# CITY OF ALBUQUERQUE

**Re: Murphy Express, SE San Mateo & Zuni, Traffic Circulation Layout  
Engineer's Stamp dated 7-2-13 (L18-D079)**

GRADING AND DRAINAGE PLAN

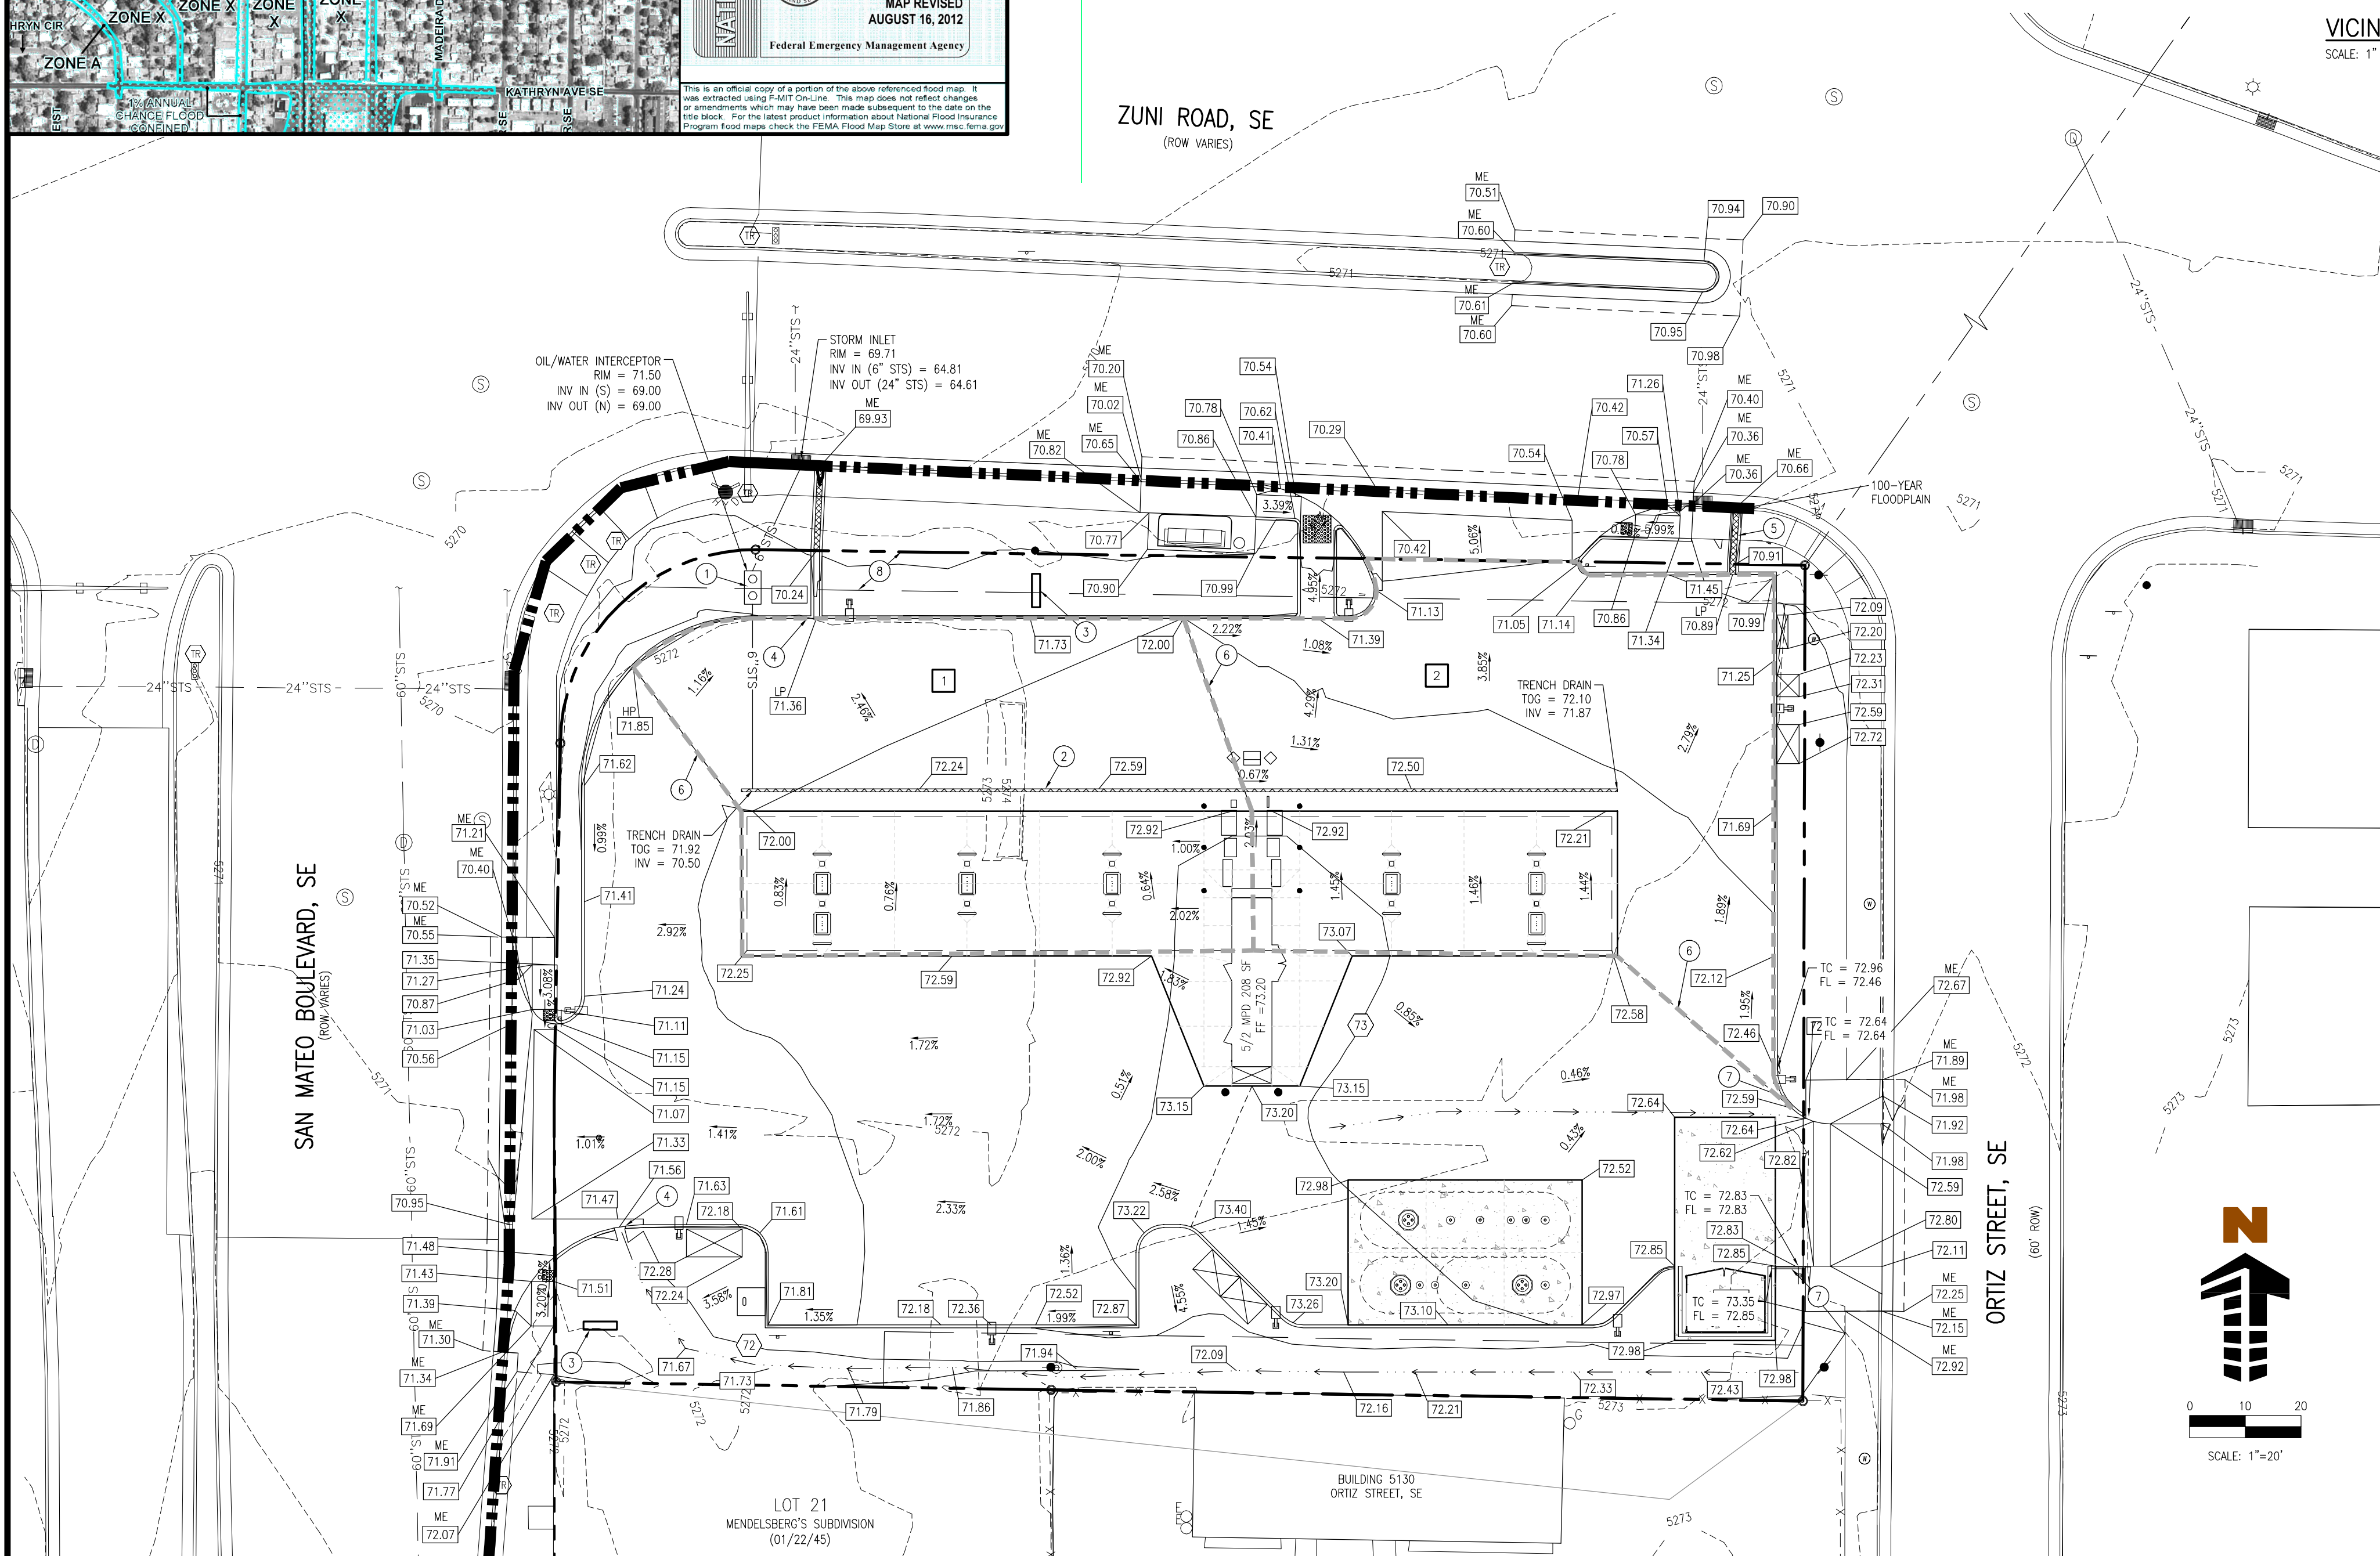
5. The abandoned drive pad proposed to be removed on Zuni must have a note indicating that it will be replace with sidewalk, curb and gutter per COA standards.

6. Please reference COA standard drawing for proposed drive pads on San Mateo and Zuni with associated ramps, valley gutters, and curb returns or provide design details.

7. Is a header curb warranted on the southern property line to contain landscaping?
8. Asphalt patches to public roadway must be a minimum of 1 foot in width.
